Recommendation Report

LU/94/13

SUBJECT: LU/94/13-Create a dropped curb and vehicle crossover.

40, Wick Street, Littlehampton, West Sussex, BN17 7JH

A284

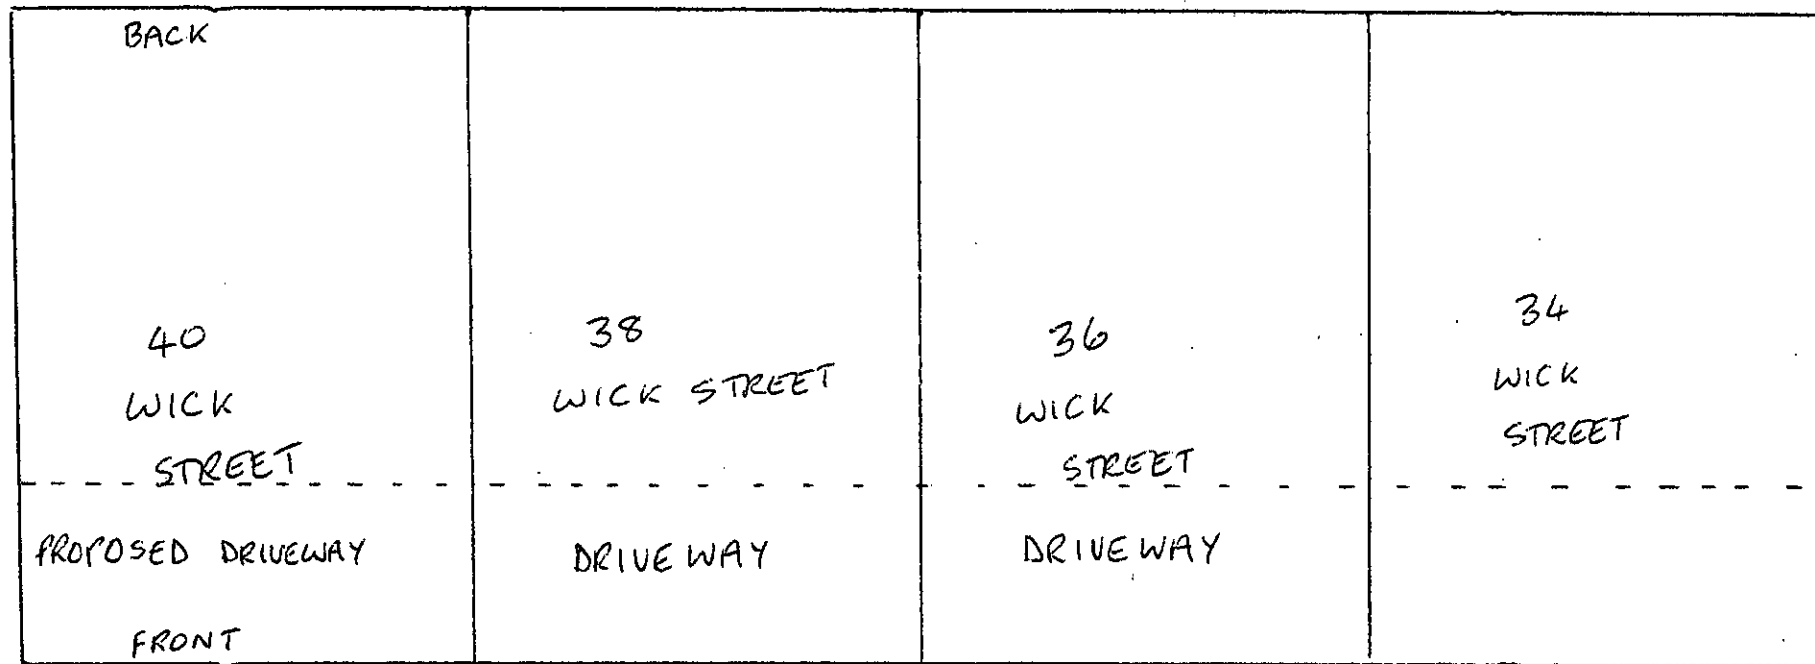
Please amend the location plan so that the proposed dropped kerb and crossover are edged in red and with the remainder of the property edged in blue.

**Drawing:
Block and site plans**

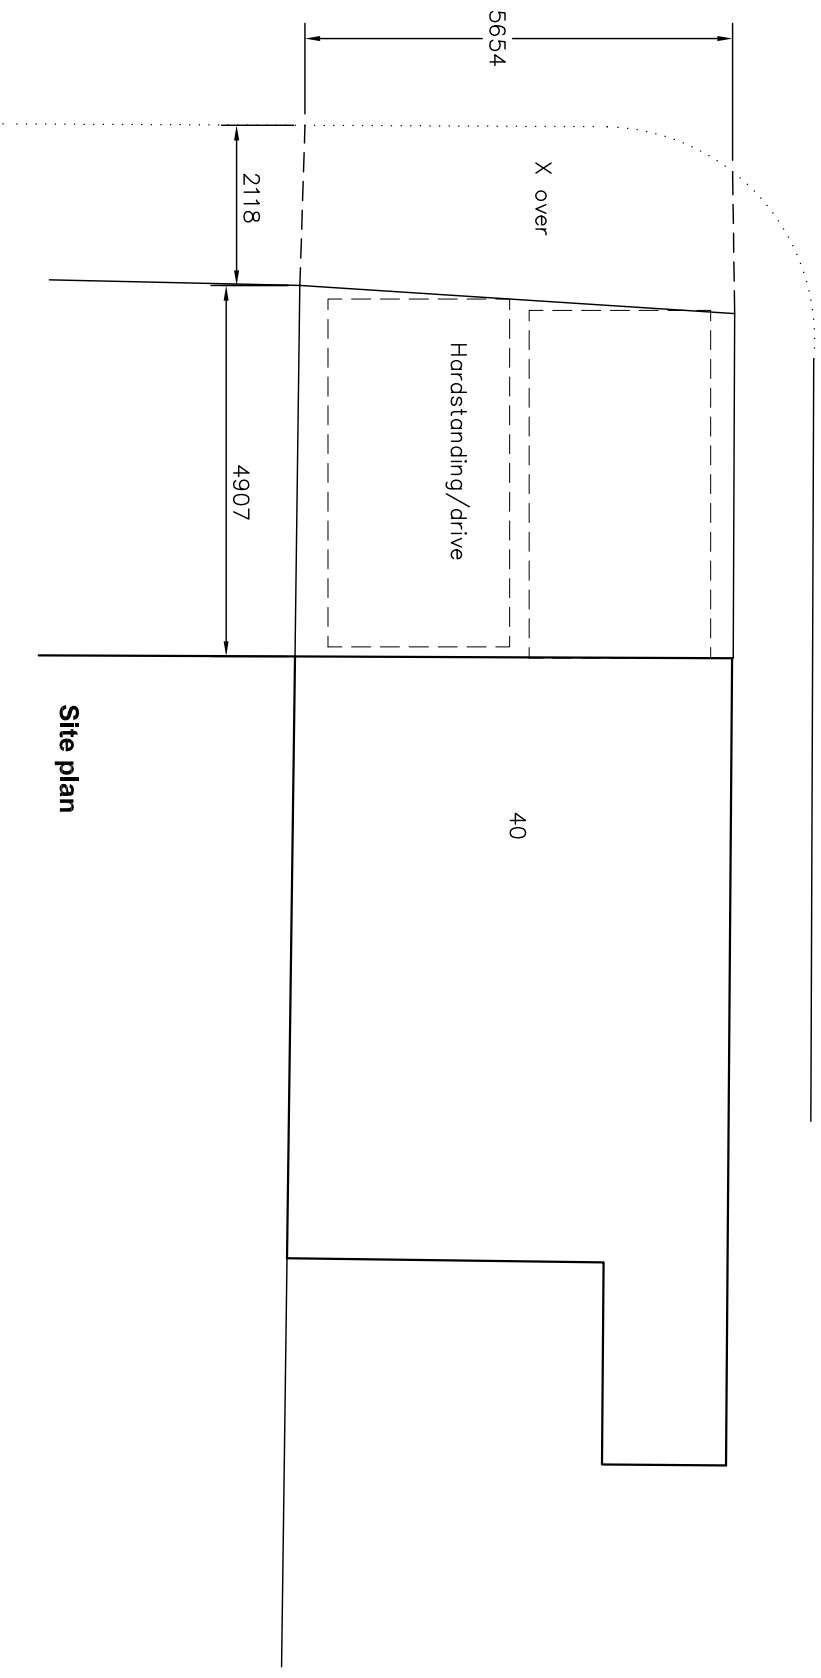
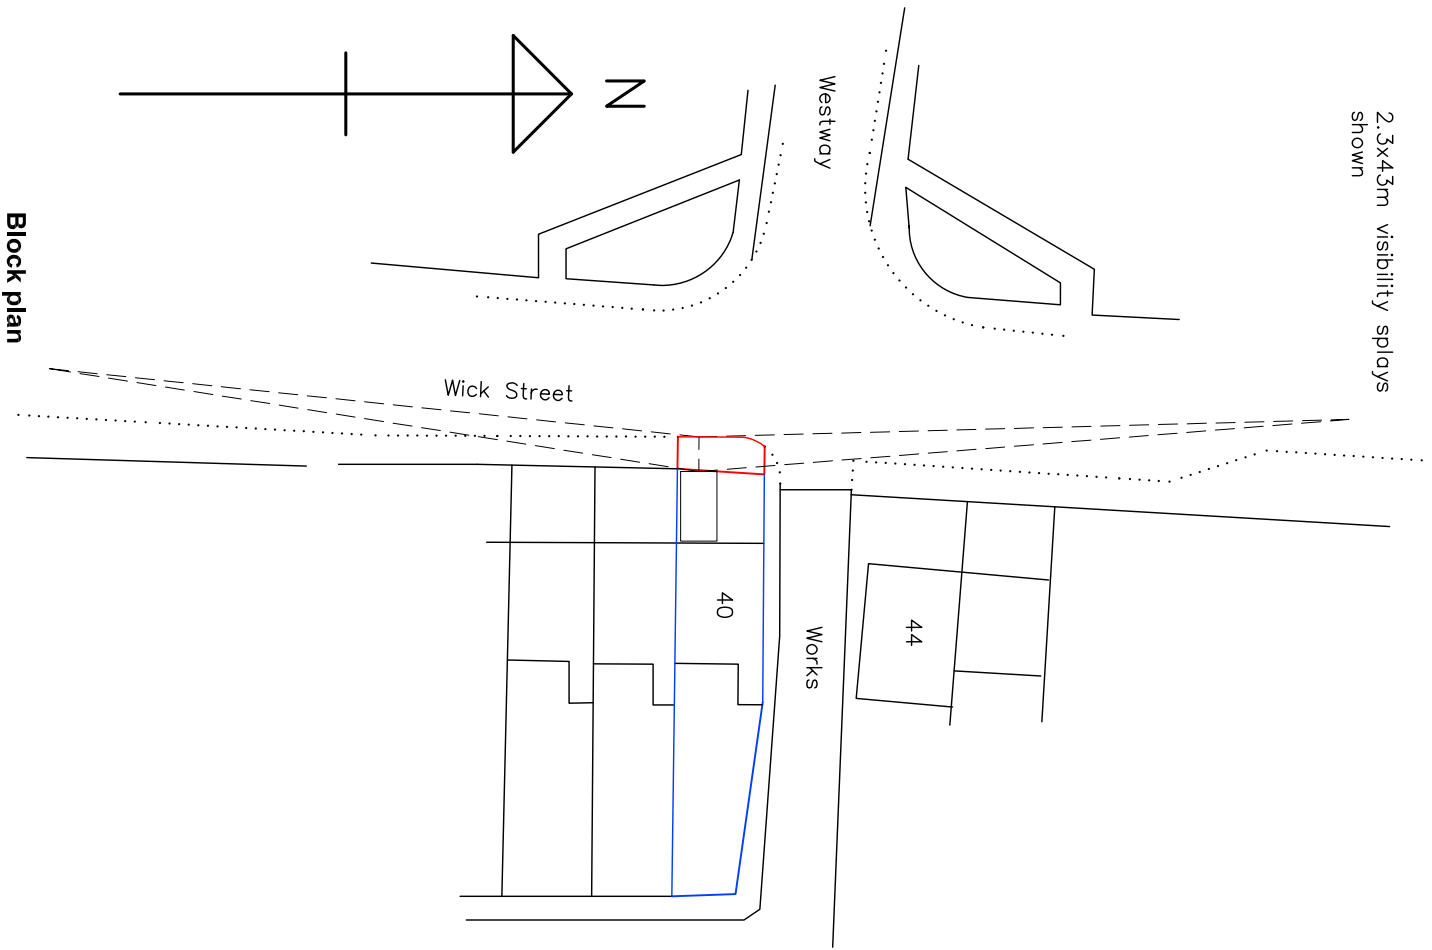
Please provide exact measurements on the site plan (including the depth).

Please revise the larger layout plan to include a scale, all measurements & with the visibility splays clearly indicated.
